## Report of the Head of Planning, Sport and Green Spaces

**Address** 165 WOODROW AVENUE HAYES

**Development:** Erection of a single storey rear extension which would extend beyond the rear wall of the original house by 6 metres, for which the maximum height would be 3.2 metres, and for which the height of the eaves would be 2.940 metres

**LBH Ref Nos:** 10594/APP/2013/2847

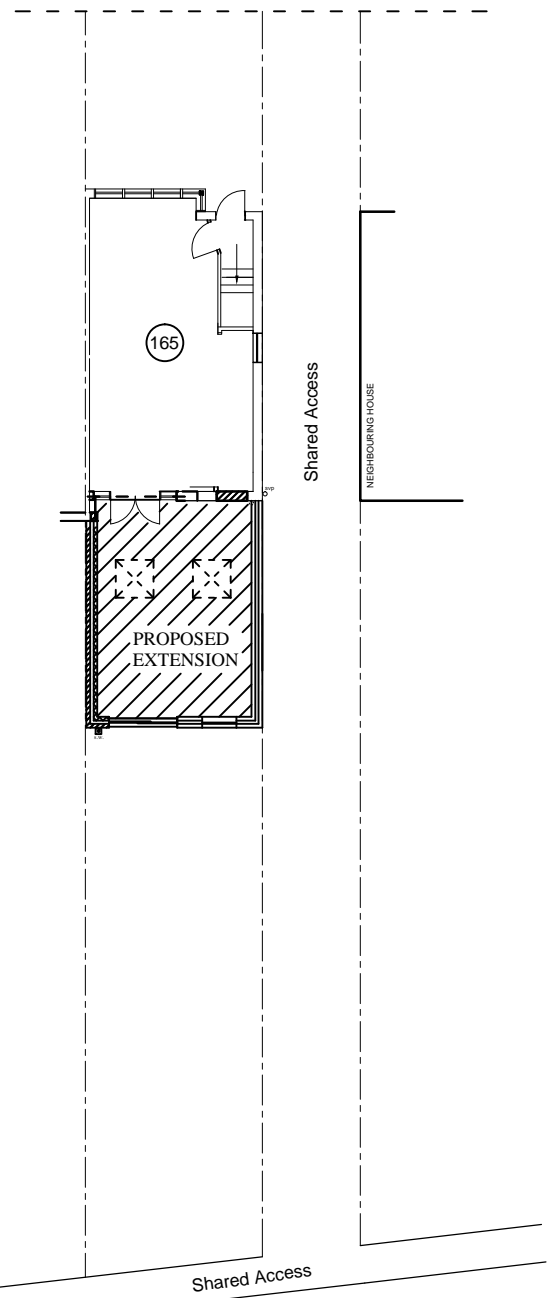
Paragraph 3.3 of HDAS requires single storey rear extensions to properties that have a width more than 5m, to be a maximum of 3.6m deep, in order to protect the neighbouring occupiers from a loss of daylight and sunlight. The proposed extension would project 6m in depth, have a pitched roof at a maximum height of 3.2m and would therefore exceed the maximum dimensions of the HDAS guidance. The adjoining property, Number 167 Woodrow Road has been extended to the rear, by way of a single storey flat roofed extension projecting approximately 3m to the rear, approximately 2m away from the boundary. A bay window projection has also been added adjacent to the boundary. It is considered that the proposed extension at a depth of 6m and maximum height of 3.2m alongside the side boundary would represent an oppressive and overbearing form of development to the occupants of this property who would suffer an unacceptable loss of light and outlook. As such the proposal would be contrary to policies BE19, BE20 and BE21 of the Hillingdon Local Plan Part Two Saved UDP Policies (November 2012) and to the Council's Supplementary Planning Documents HDAS Residential Extensions.

Number 163 Woodrow Avenue is separated from the application site by a pedestrian walkway. However, at a depth of 6m, the proposed extension would still represent an oppressive and overbearing form of development to the occupants of this property who would suffer an unacceptable loss of light and outlook. As such the proposal would be contrary to policies BE19, BE20 and BE21 of the Hillingdon Local Plan Part Two Saved UDP Policies (November 2012) and to the Council's Supplementary Planning Documents HDAS Residential Extensions.
